Our ref: 2489/01/CN1
13/10/2025

BRADLEY VILLA FARM
(PROPOSED CHANGE OF USE AND ASSOCIATED WORKS)

CLARIFICATION NOTE

TITLE DRAINAGE STRATEGY  
PROPOSED – NETWORK B  
SHEET 1 OF 1

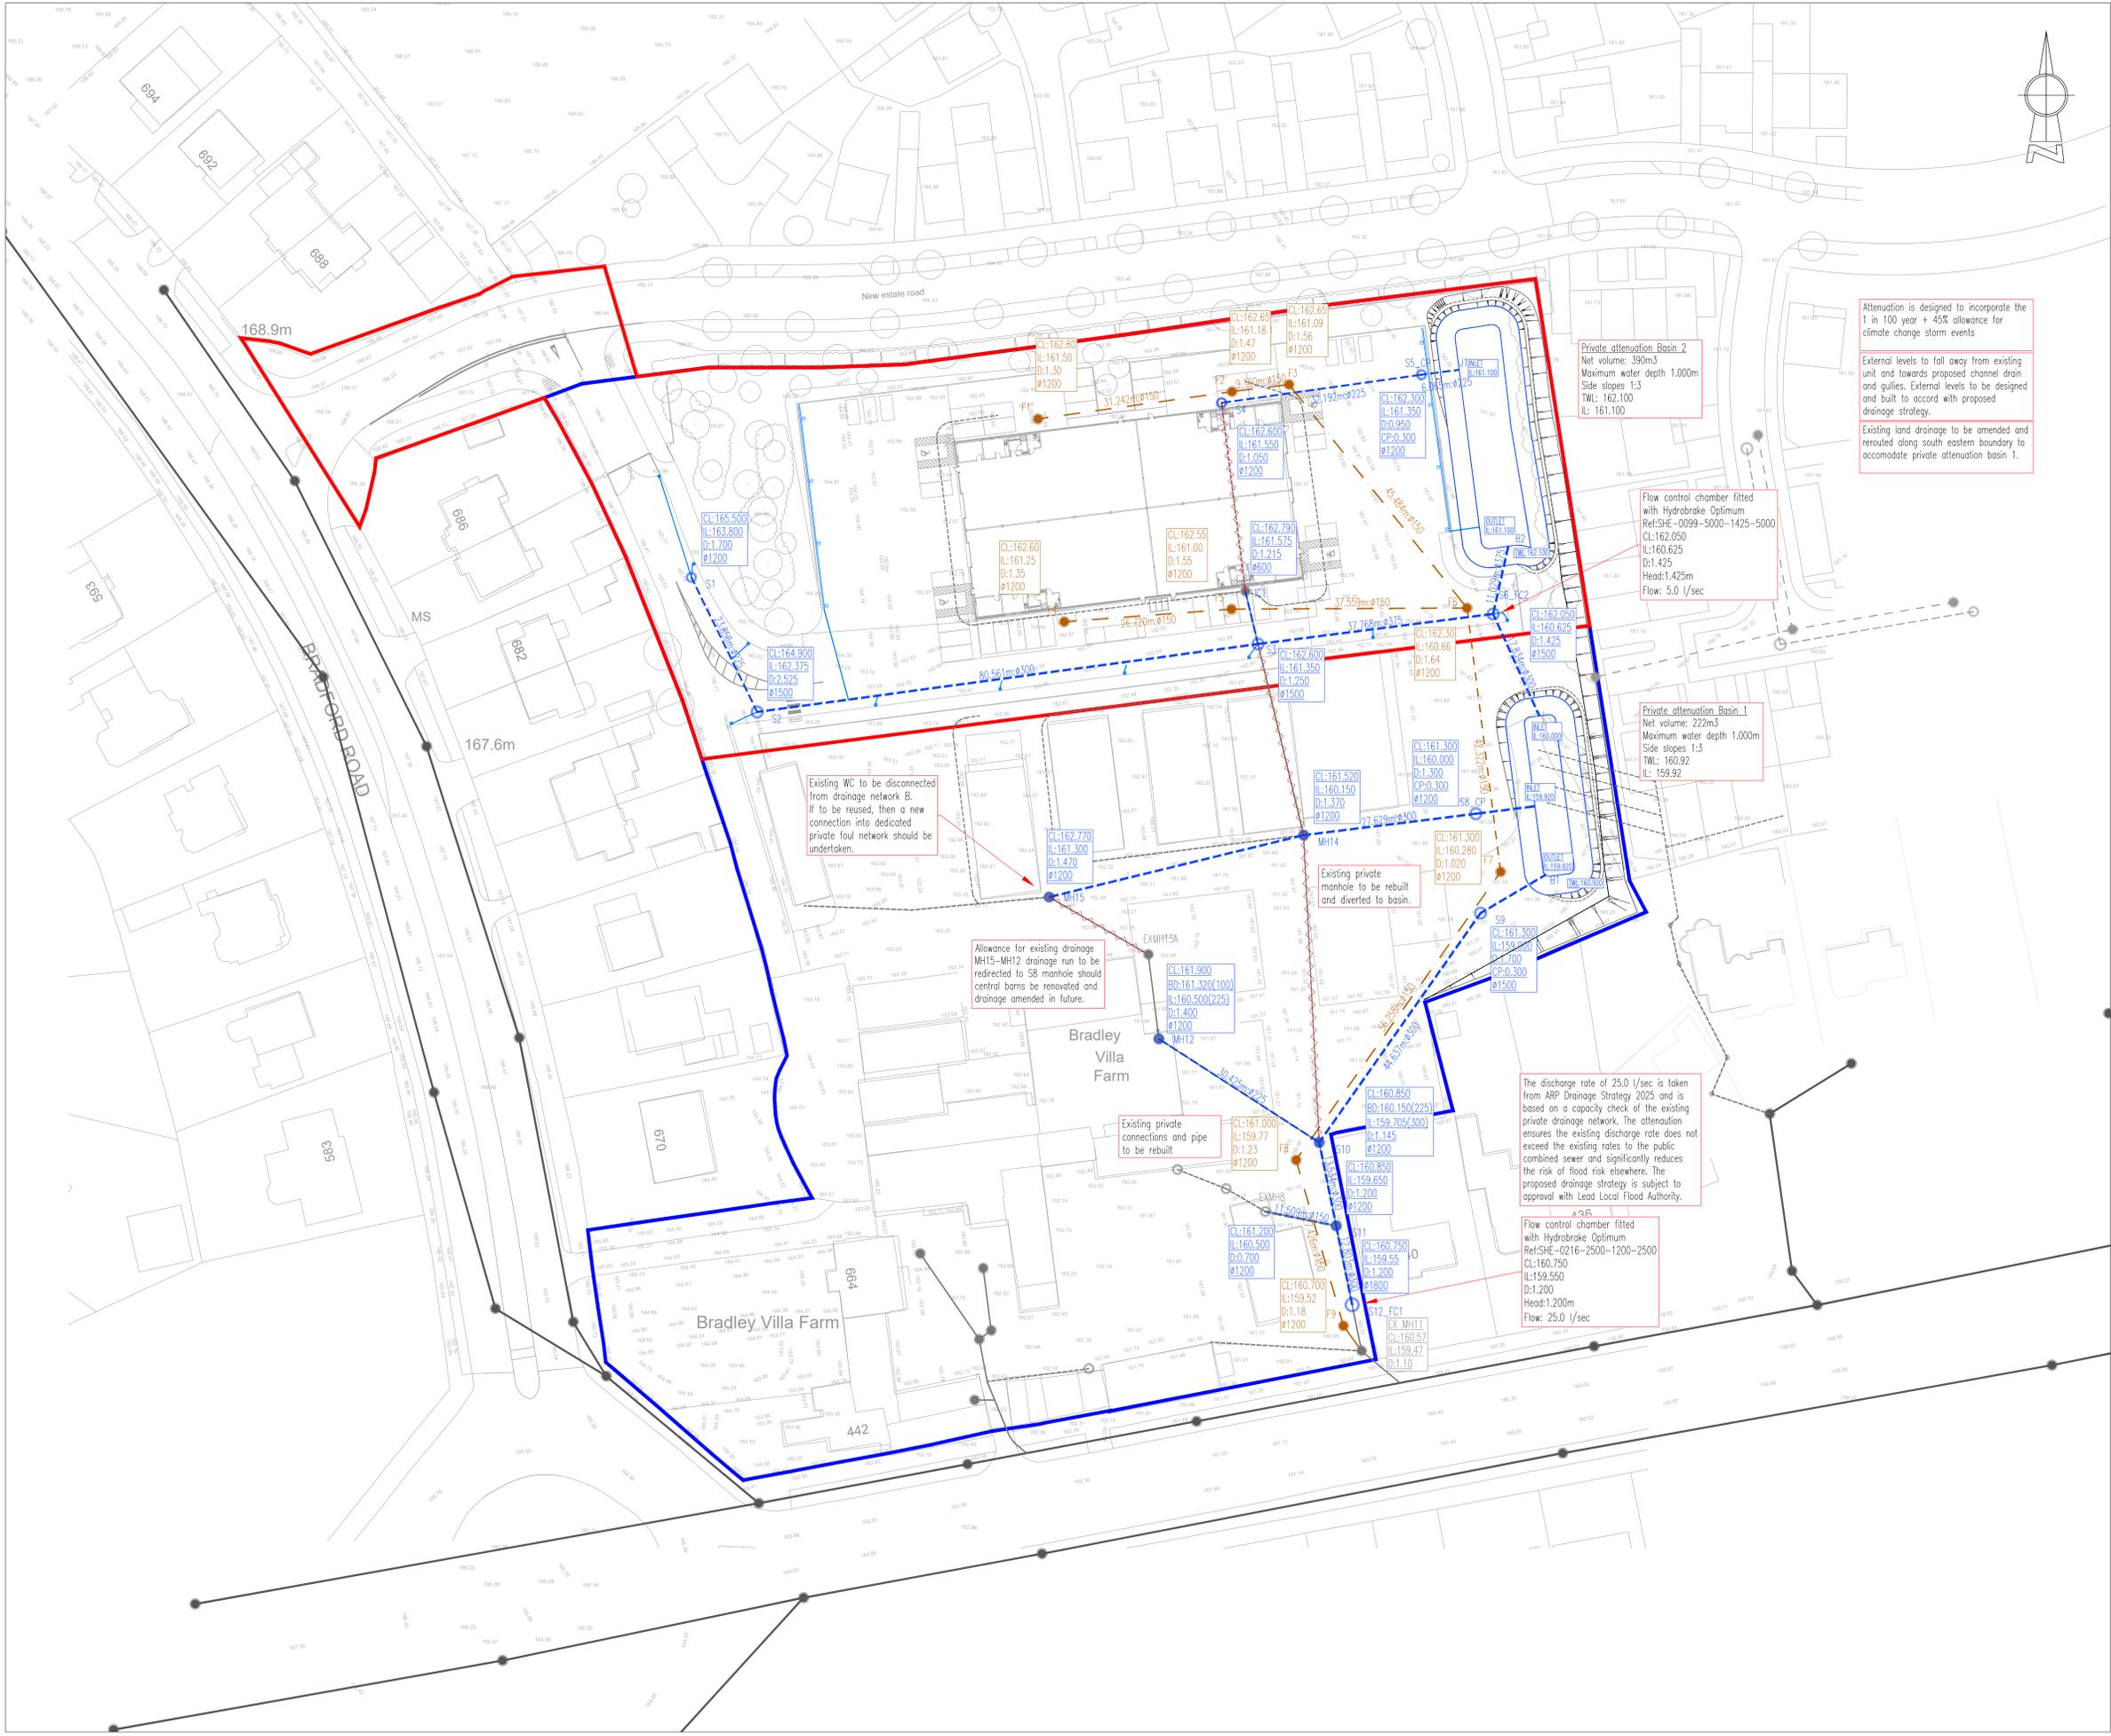
“We are however concerned at the amount of flooding that this system produces in a 1 in 100 year plus climate change storm event as no evidence had been provided to demonstrate that the water can be safely held on site.”

- 2.5 In order to meet with the LLFA's requirements and robustly address their comments, further drainage works at the site are proposed to ensure there is no flooding following redevelopment during the 1 in 100 year plus climate change event. An additional section of the existing drainage is to be rebuilt (manhole EX MH15) at increased depths to ensure that there is no flooding from this remaining manhole. The revised drainage arrangements are shown within **Appendix 1.**

- 2.6 As a result of amending EX MH15 and redirecting the pipework into MH14 which goes into the attenuation Basin 1, the site is now future proofed and ensures there is no flooding during the 1 in 100 plus 45% climate change event. The revised network calculations are provided within **Appendix 2.**
